# DETENTION BASIN OUTLET STRUCTURE DESIGN

Project: Winsome Filing 3

Basin ID: H5B (INSTALLED DURING EARLY GRADING PHASE)

STANDARD RISER PIPE DETAIL
N.T.S.

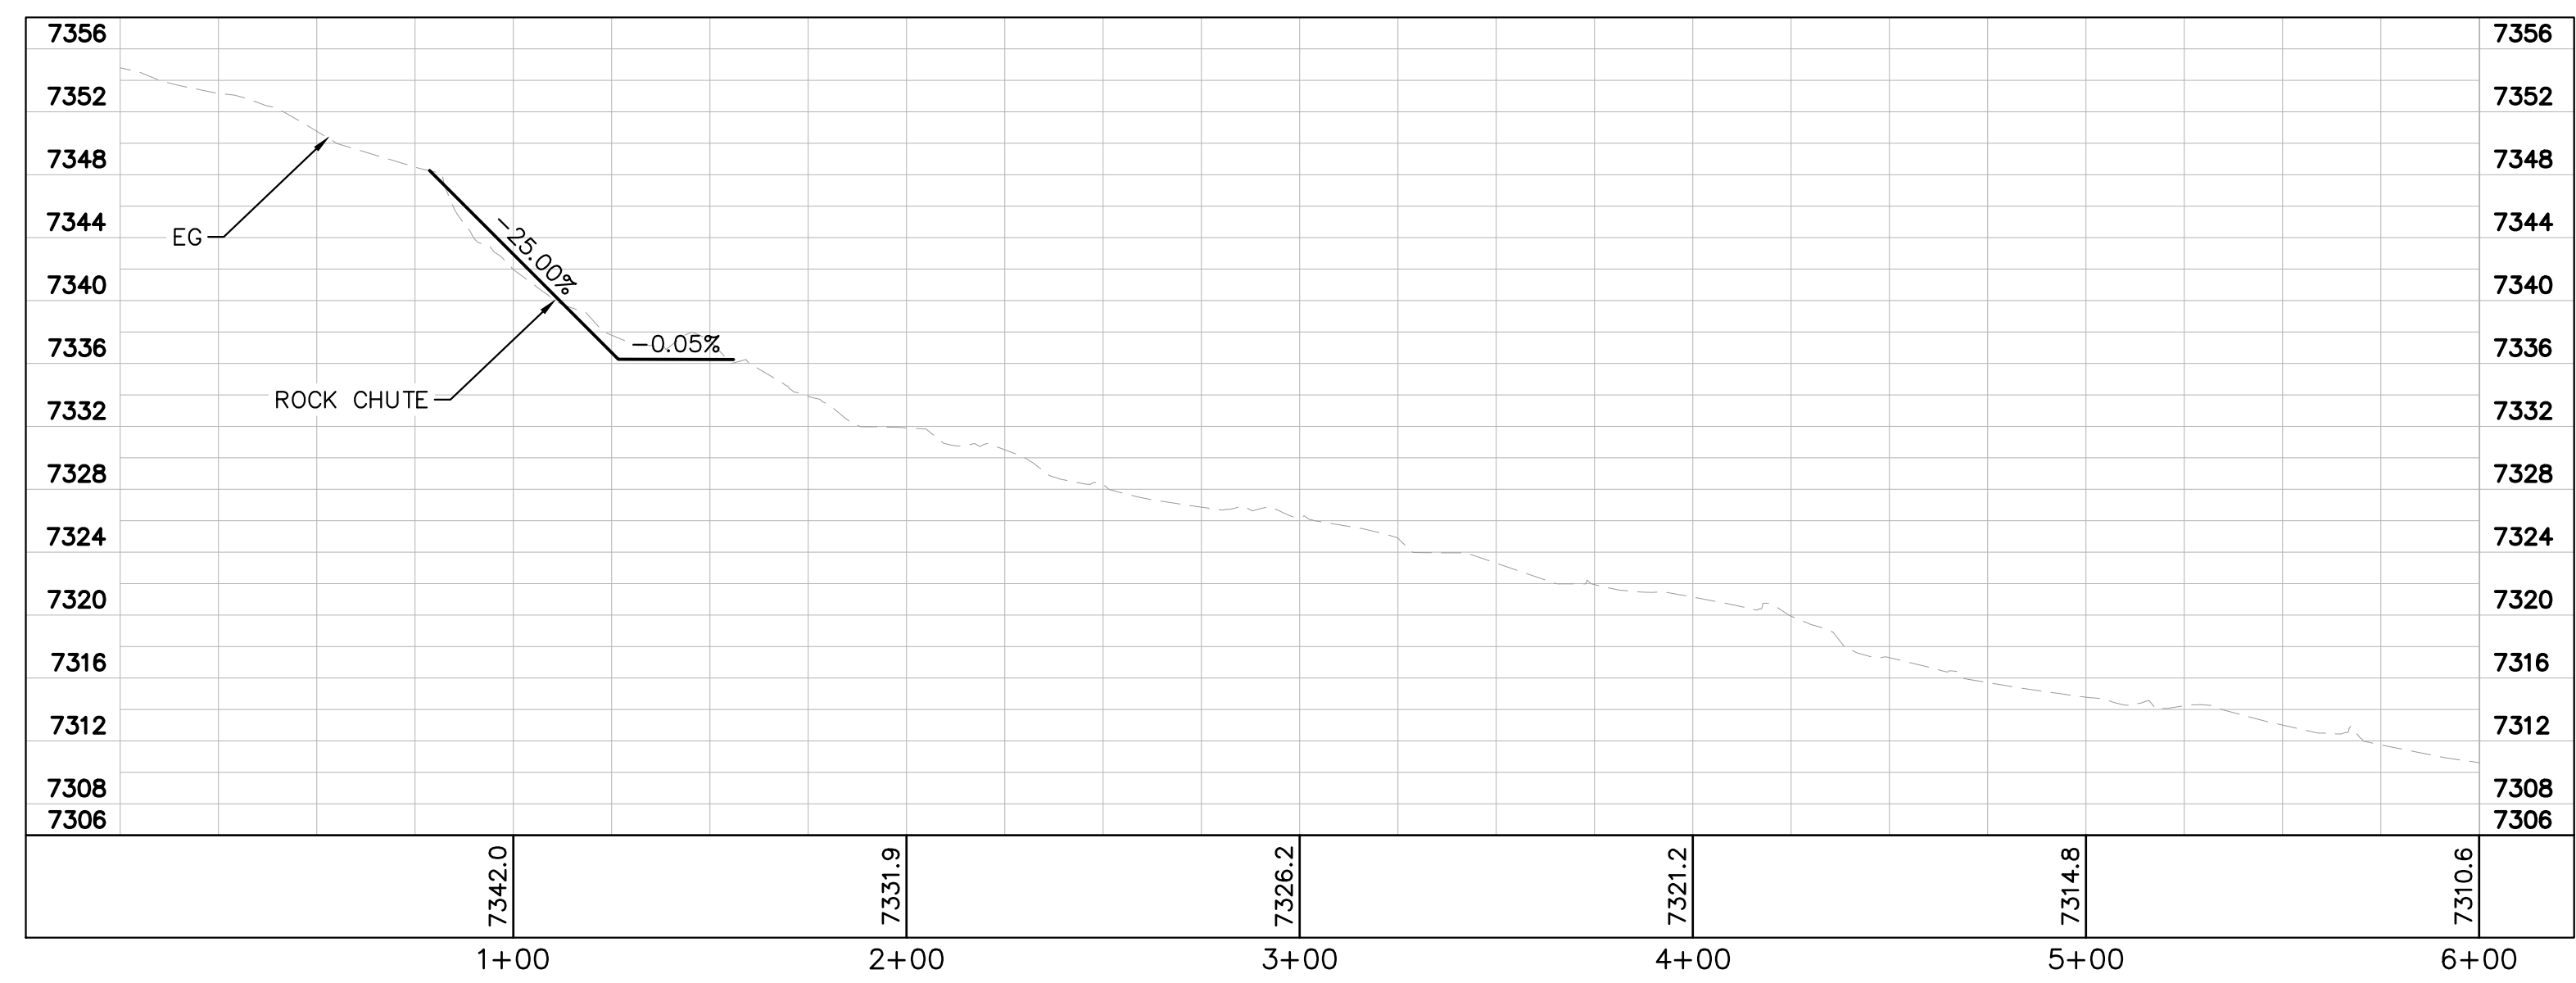
drain time should be at or near 72hrs for a sediment basin

Unresolved. See snippet above for MHFD DCM vol 3 criteria regarding sediment basin drain time.

Additionally update the GEC plan to provide either a trash rack or packed gravel in front of the orifice. Unclear what on the current design will prevent the orifice holes from being blocked/clogged as sediment builds up.

**KHA RESPONSE:**  
DESIGN HAS BEEN UPDATED TO SHOW WQCV BEING MET AND A TRASH RACK HAS BEEN PROVIDED TO PREVENT THE ORIFICE HOLES FROM BEING BLOCKED/CLOGGED.
